**RE: Lot 11 Block 6 Unit 17 Volcano Cliffs SAD 228
6532 Kimmick NW
Grading and Drainage Plan
Engineers Stamp Date 10/28/19 (D10D003M11)
Pad Certification Date 3/24/2021**

Based upon the information provided in your submittal received 8/17/2021, this plan cannot be approved for Building Permit until the following comments are addressed.

ENGINEER'S SEAL	6532 KIMMICK	DRAWN BY WCWJ
	GRADING AND DRAINAGE PLAN	DATE 3-22-21
		21021029-LAYOUT-3-22-21
DAVID SOULE P.E. #14522	1606 CENTRAL AVENUE SE SUITE 201 ALBUQUERQUE, NM 87106 (505) 872-0899	SHEET # JOB # 21021029

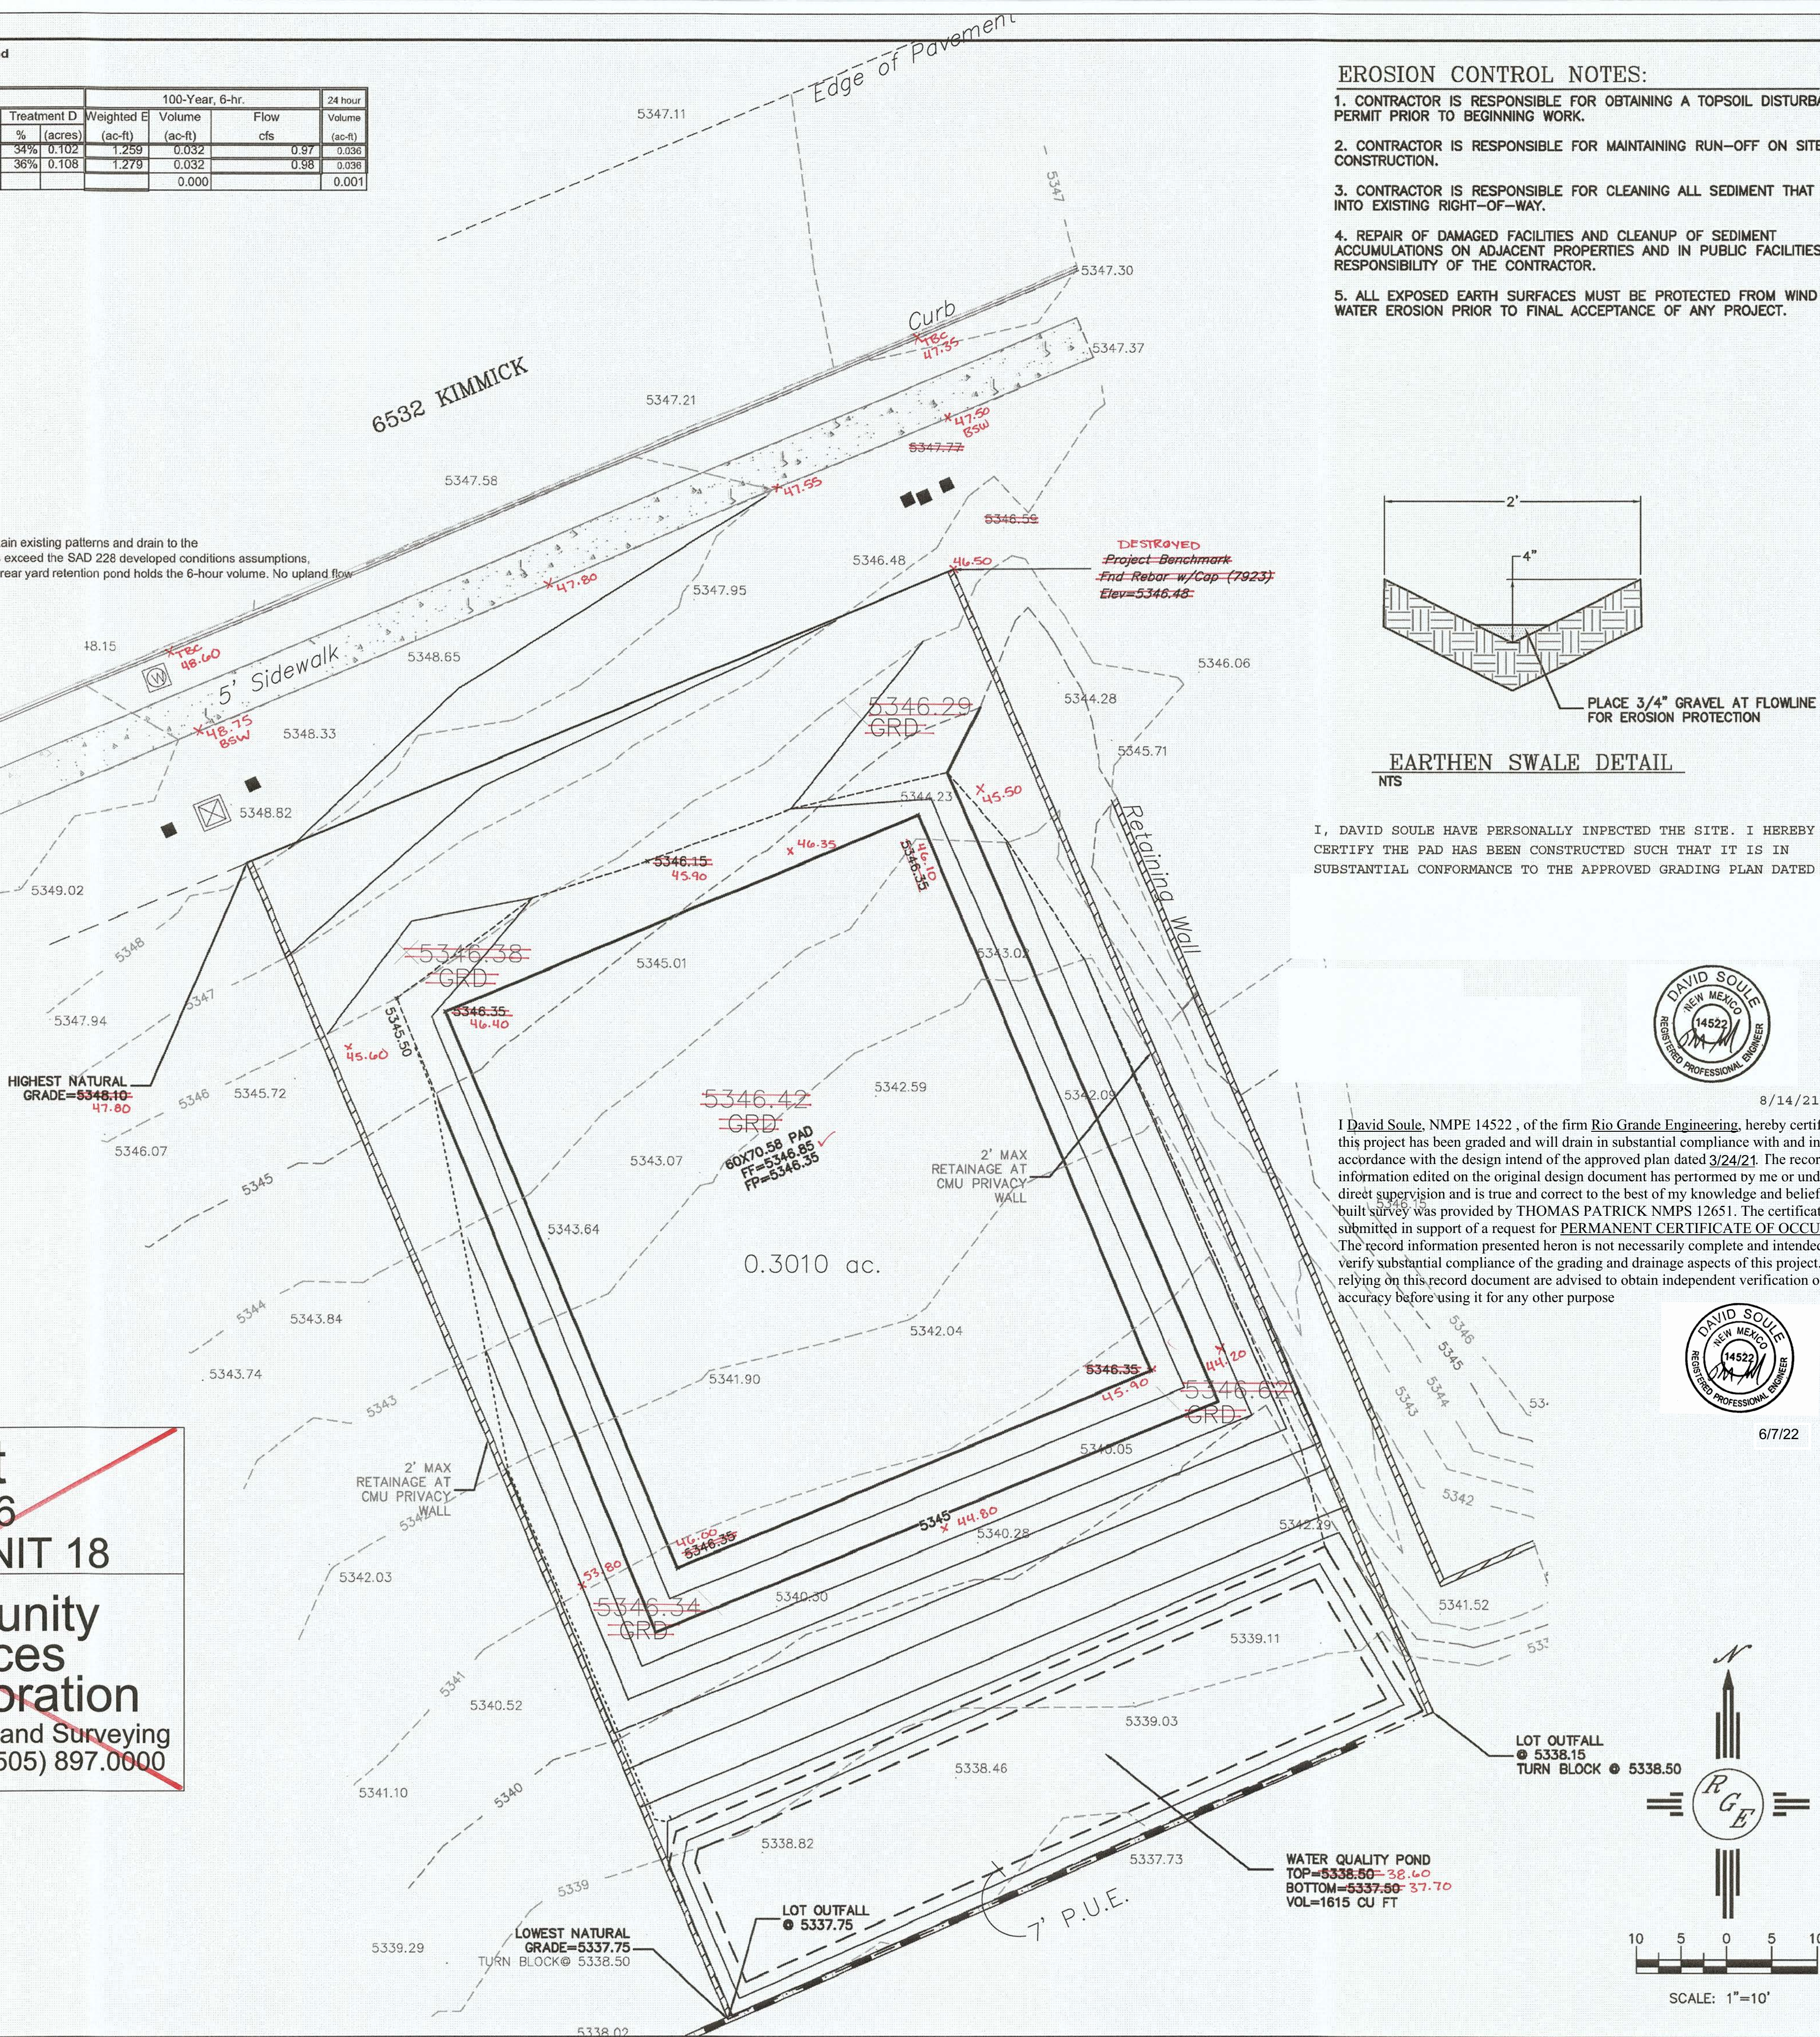
- Provide erosion protection for the building pad. The building pad is too high and the slope is too steep.
